A.M. Wright
12 Parkes Lane
Terranora NSW 2486

29th March 2011

**Re: The development of Altitude Aspire- Project No 090166—Fraser Drive
Terranora N.S.W.**

D:\PROJECT APPL No. MP09-0166		SK2712
09-374	17-11-2010	REVISION 1

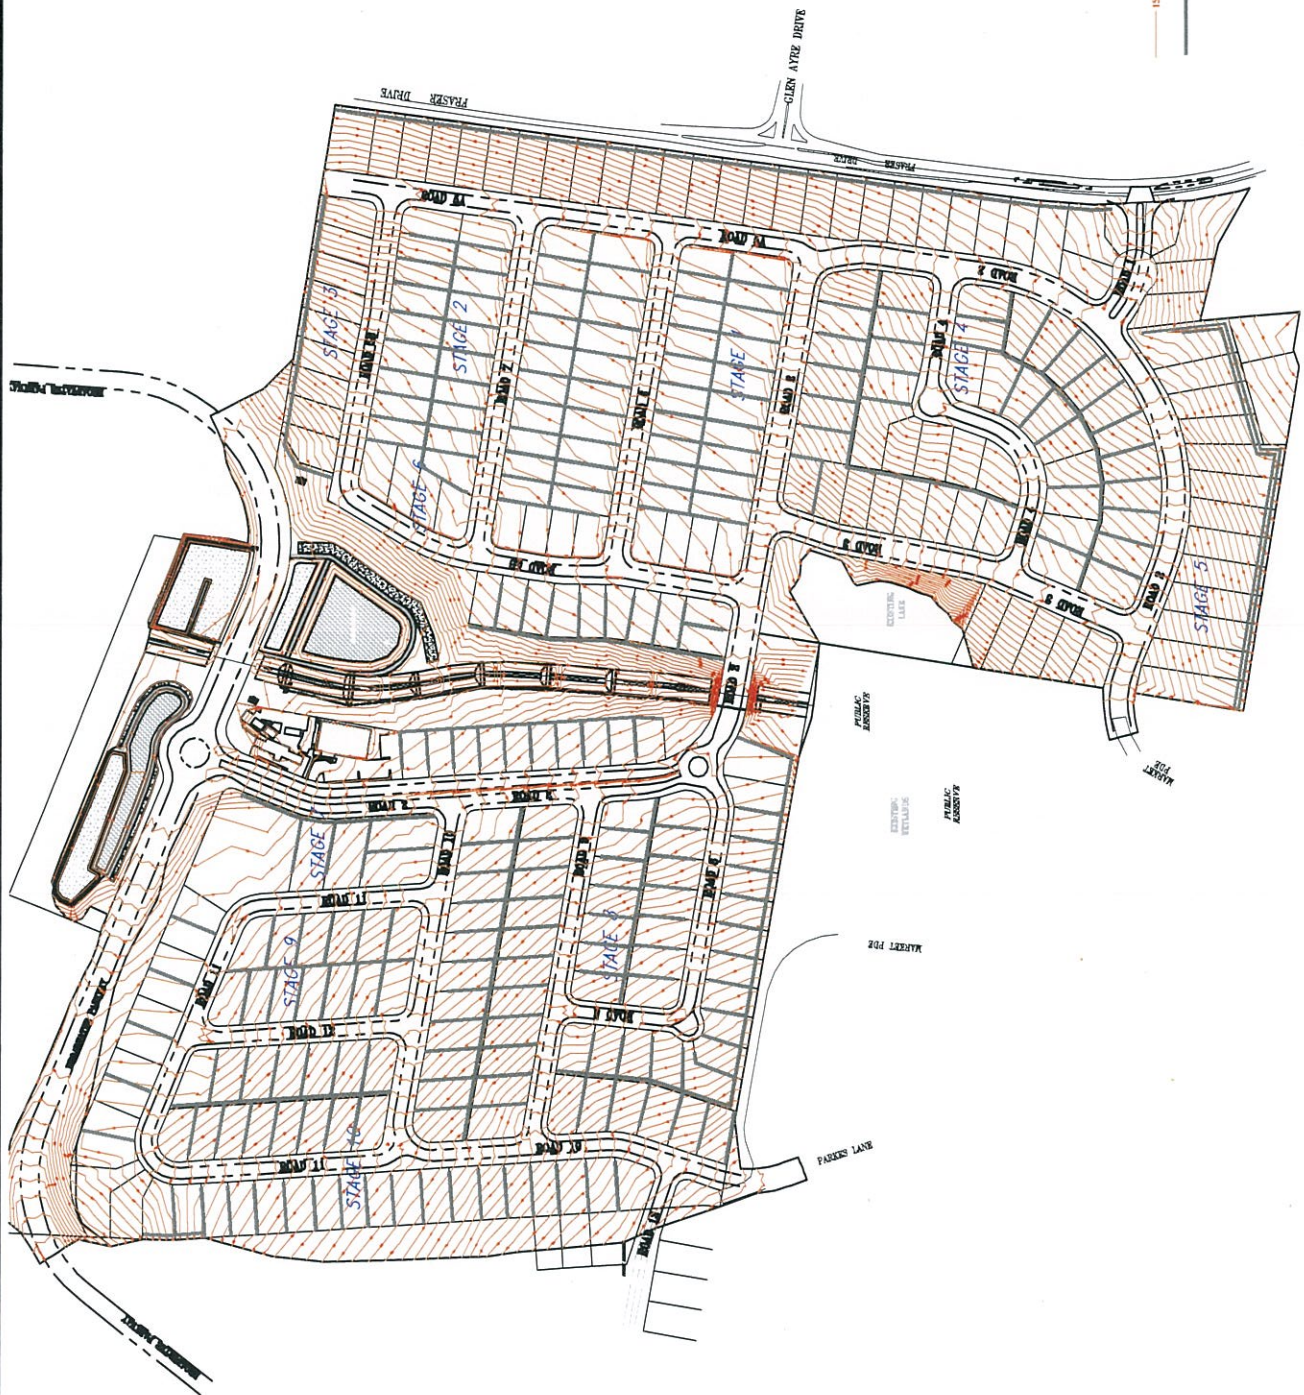
- As a consequence of the existing topography, and the proposed earthworks, it is expected that approximately 18 % of the site will require earthworks greater than 5.0m depth. Centrally the development will require cut and full up to 13.5 m over the natural water course and movement of material across the whole of area E. Some slope sections are greater than 25%. (Ref Bradlees Consulting Cut and fill – Legends section 5 and Slope Analysis 17/11/2010 See attachment 2/3)

D.A. PROJECT APPL. No. MP09-0166 **SK2741**
 09-374 17-11-2010 REVISION B
BradLees
 CONSULTING

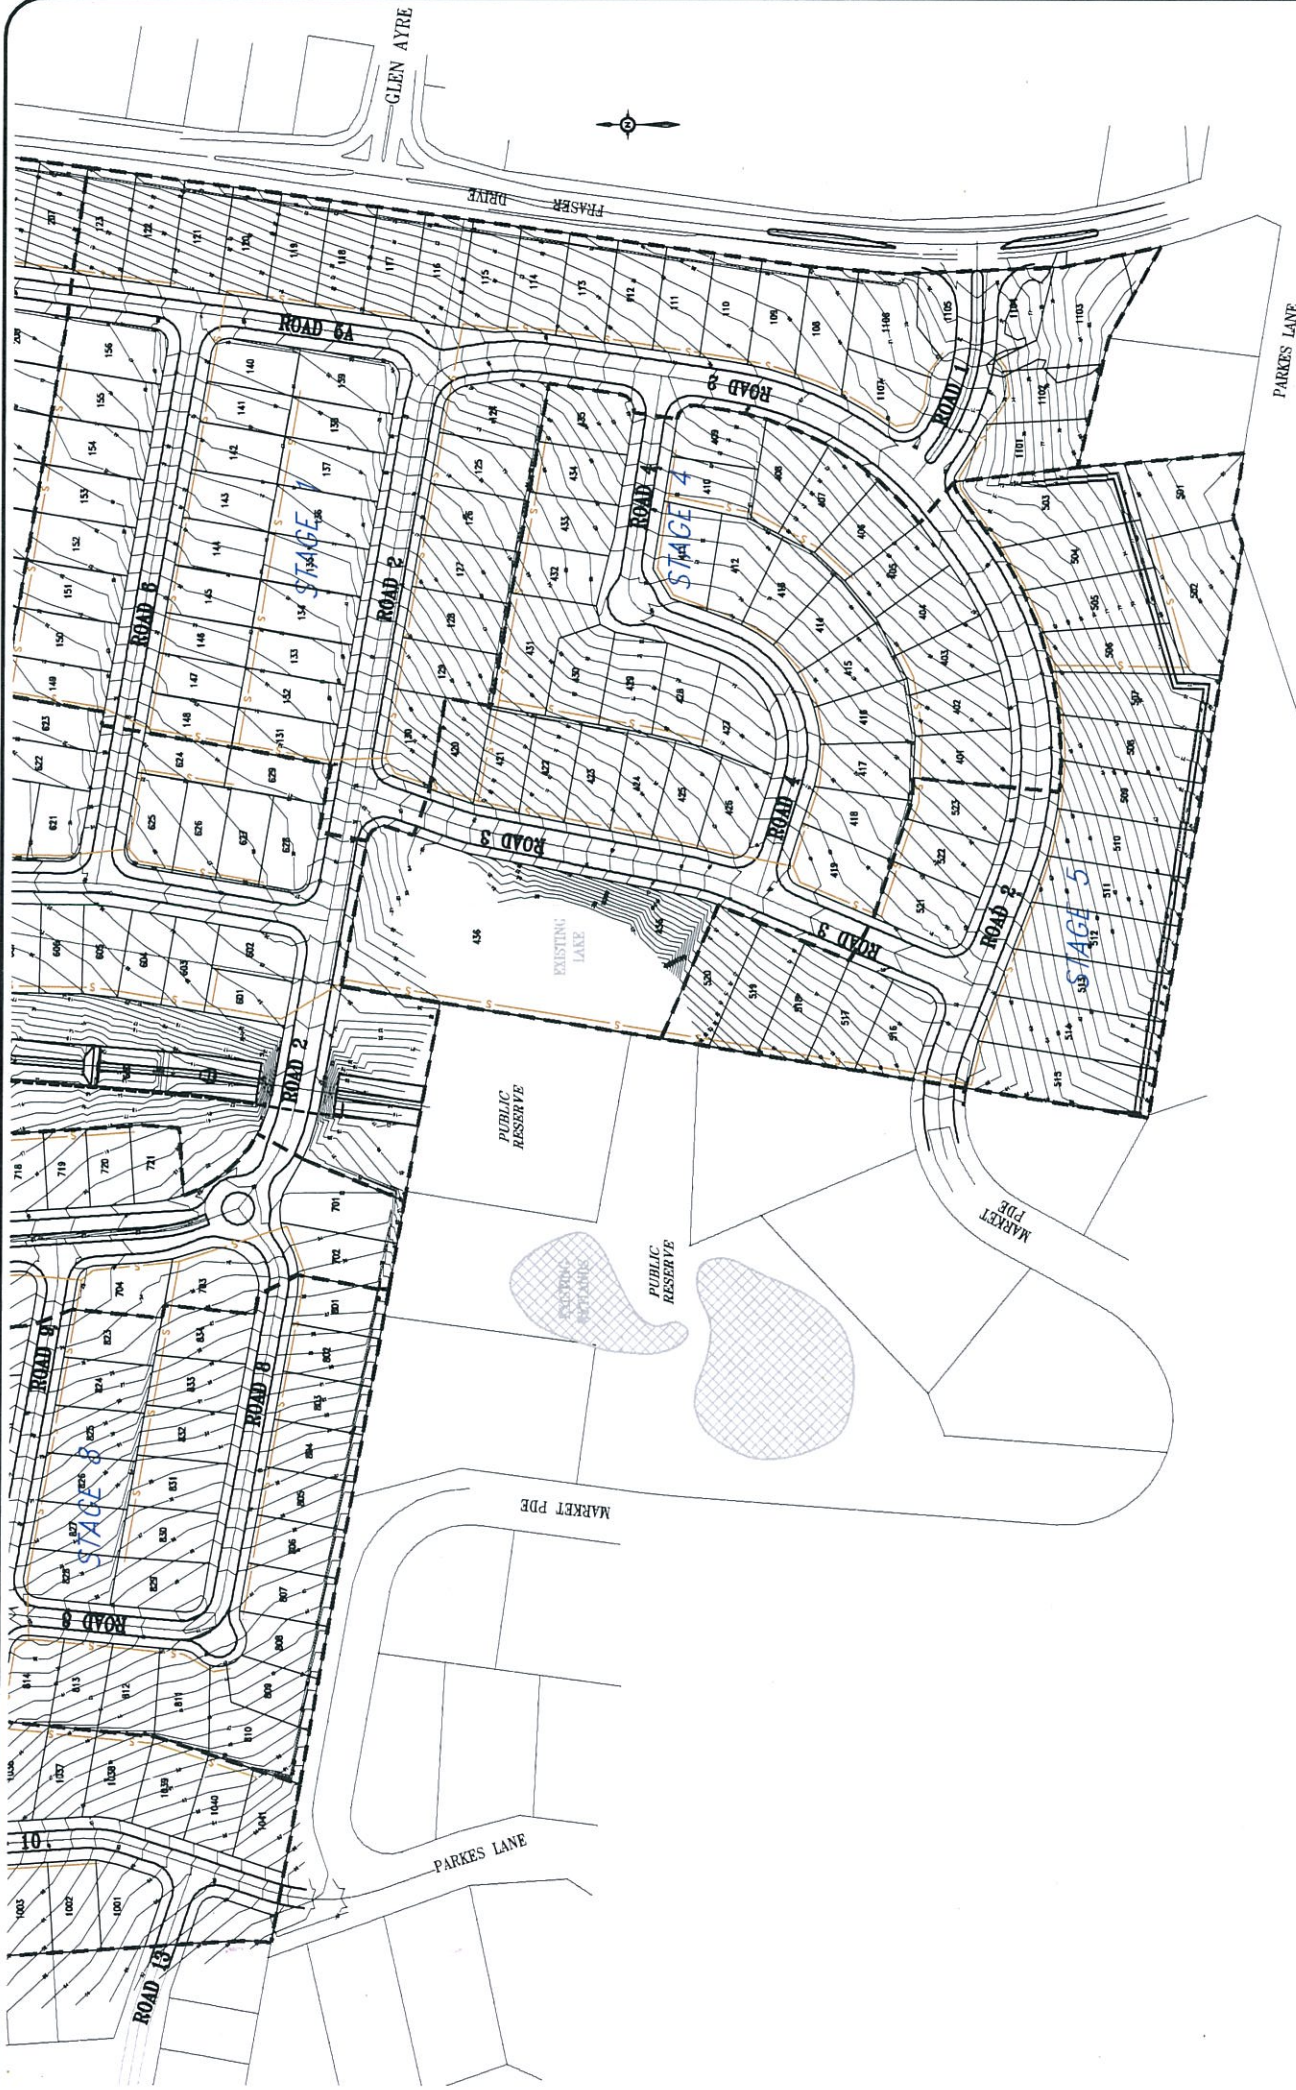
- Engineering plans SK2743 and SK2741 clearly show that there is no provision for the future connection of stormwater and sewerage for Parkes Lane, an Environmental and Public Safety Concern.

- Will future sewerage connection pipes or easements be put in place in this development?
- There is no mention of sewerage connection to existing homes, but there is mention that storm water treatment and management systems are to be implemented. Up stream catchments external to Altitude Aspire are to be conveyed through the site (via the central Open Drain) with out the need to pass through the treatment basin.(Bradlees Civil Consulting Report Revised Prelim. Nov 2010.) However not so according to SK2743 and SK2741 Engineering Plans.
